10 June 2009

DISABILITY ACCESS REPORT

Proposed New Clubhouse, Marina Extensions + Carpark Alterations
LAKE MACQUARIE YACHT CLUB
Ada Street
BELMONT NSW

for:
Lake Macquarie Yacht Club

CLIENT: **LAKE MACQUARIE YACHT CLUB** DRAWING: **CAR PARK ALTERATIONS PLAN**

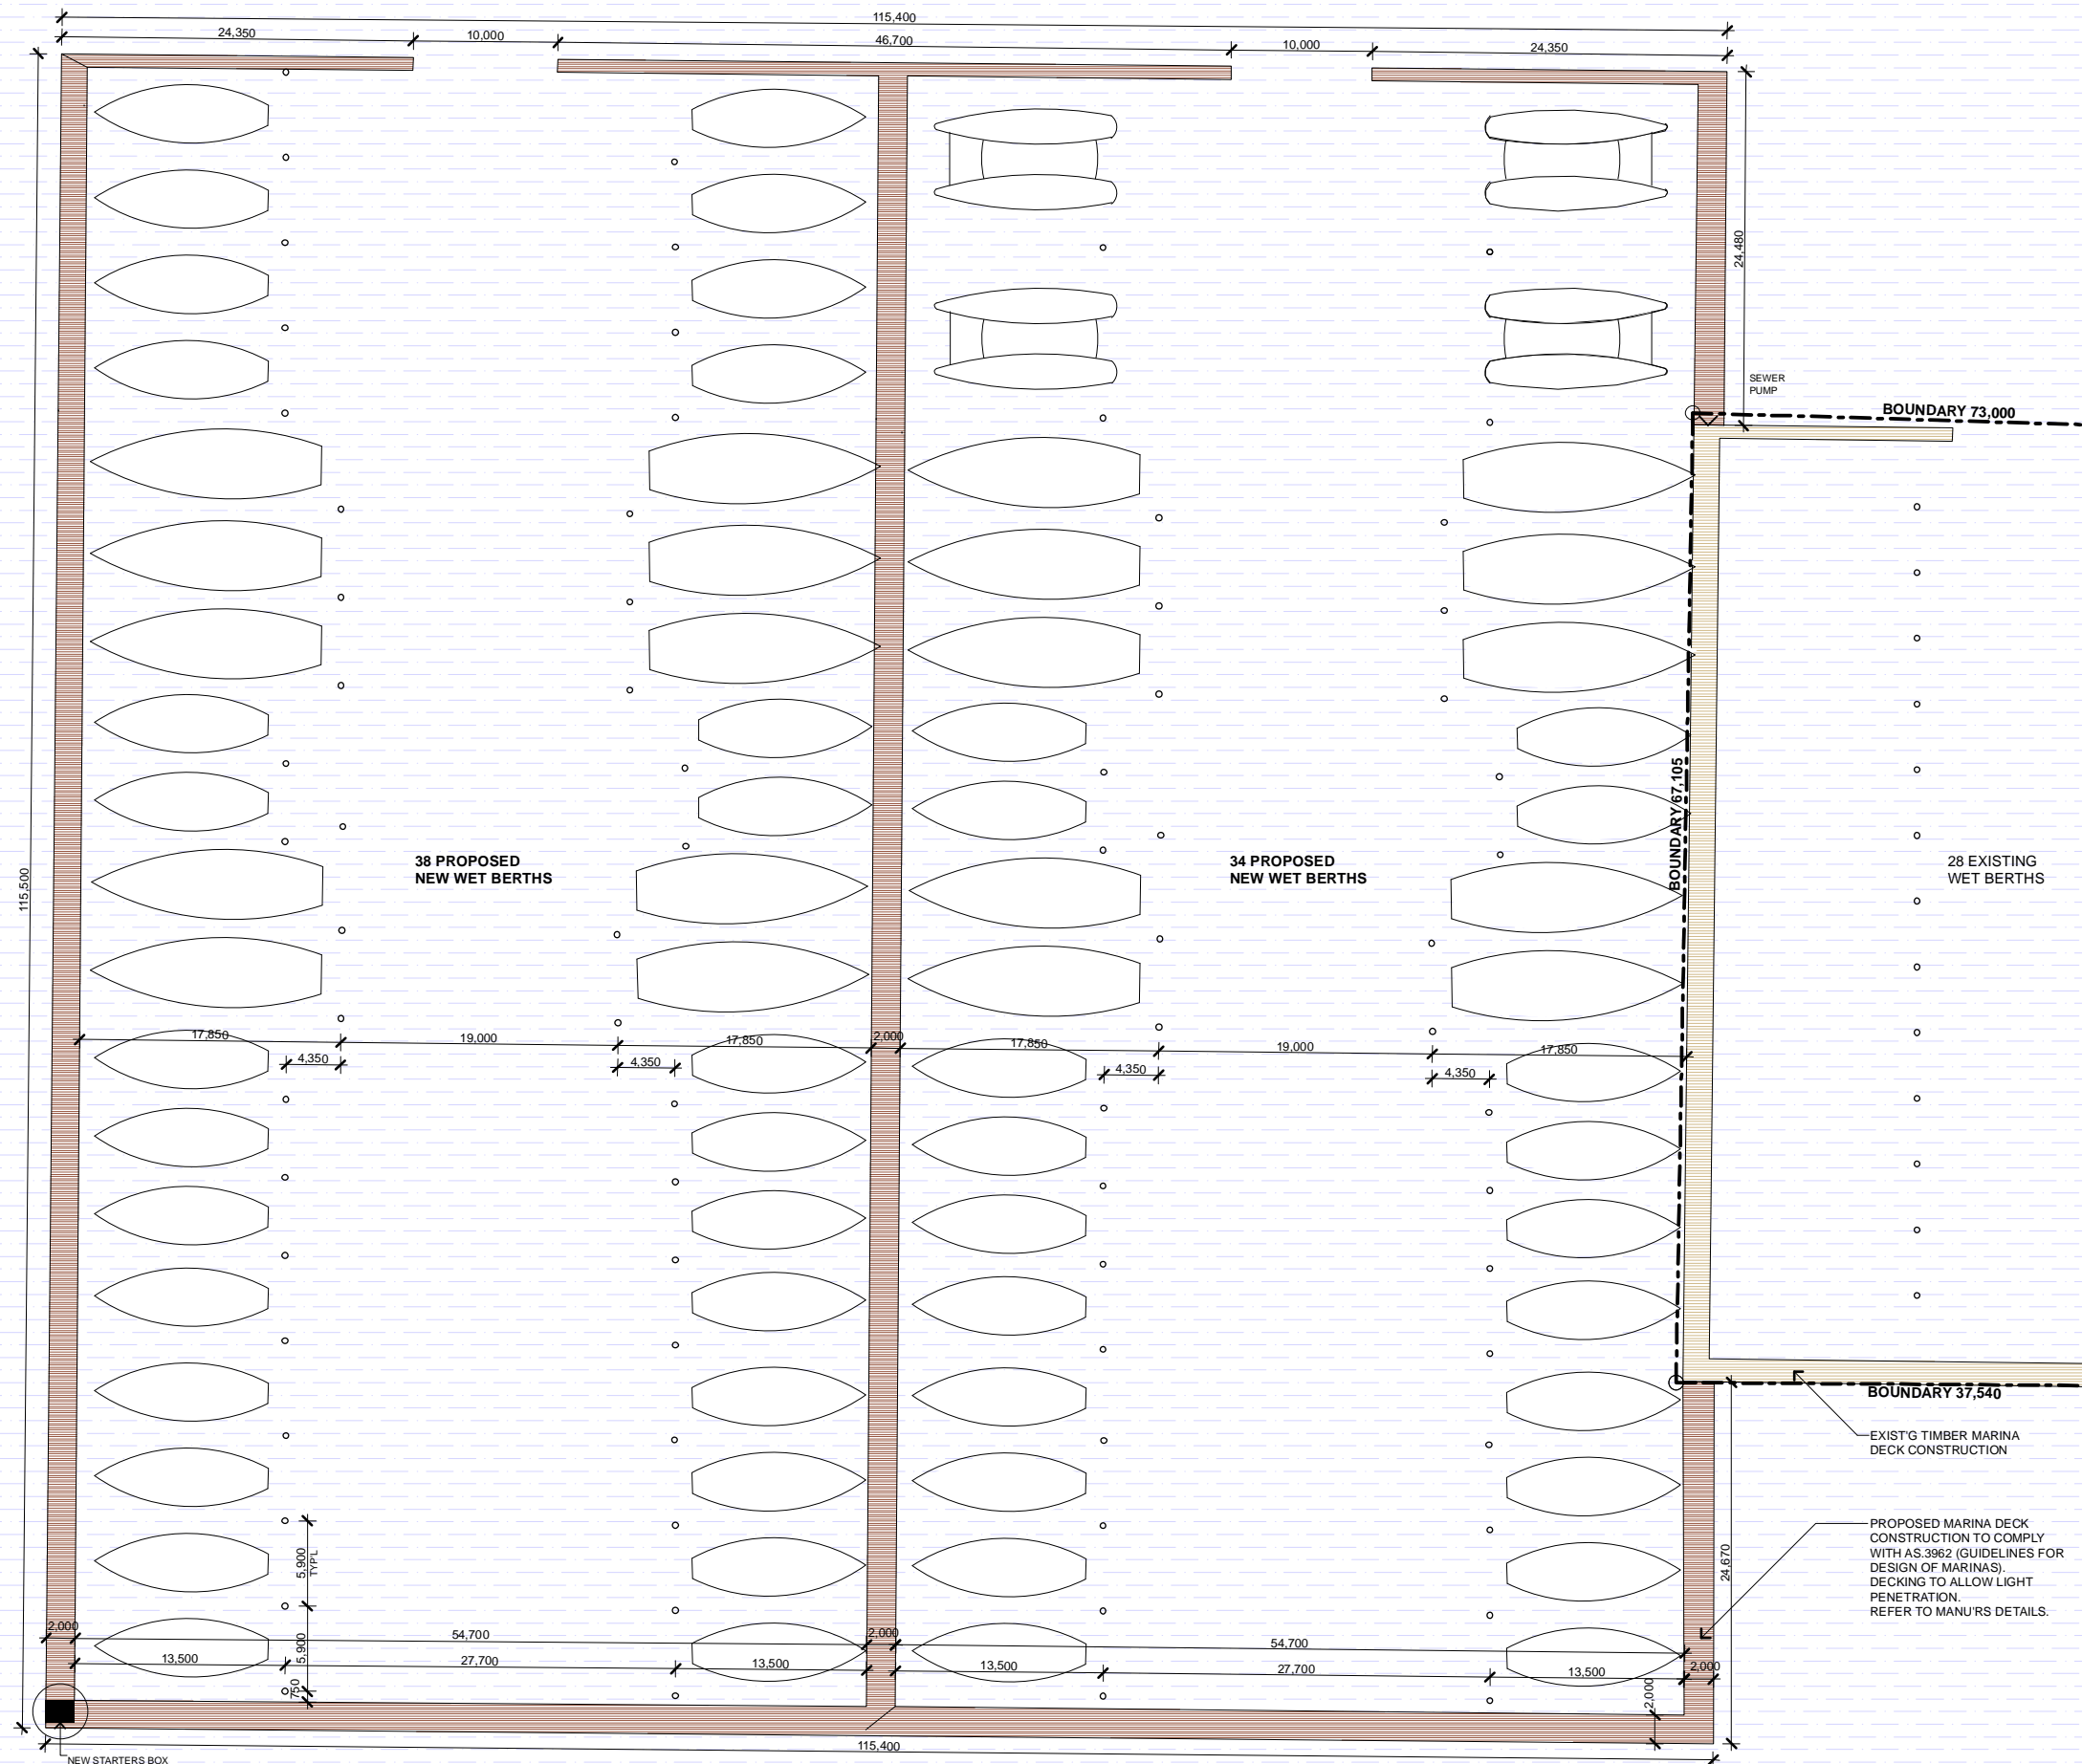
Three accessible carparking spaces are provided within the carpark and are located adjacent to the building entrance. We consider that this is adequate for this development. An accessible path of travel is provided from the accessible carparking spaces to the building entrance.

Accessible carparking is nominated as 3500mm wide, providing compliance with AS2890.1.

- a. The minimum allowable width of accessible carparking is 3200mm wide for compliance with AS2890.1.
The nominated width of accessible carparking offers compliance.
- b. The maximum allowable crossfall of accessible carparking area to be 1:40 (for concrete, 1:33 for bitumen surface). This crossfall applies both parallel and perpendicular to the direction of the carpark.
- c. Designated accessible carparking is to be identified using the International Symbol for Access (ISA) – complying vertical and ground signage is required. Signage is to comply with AS1428.1, Clause 14.
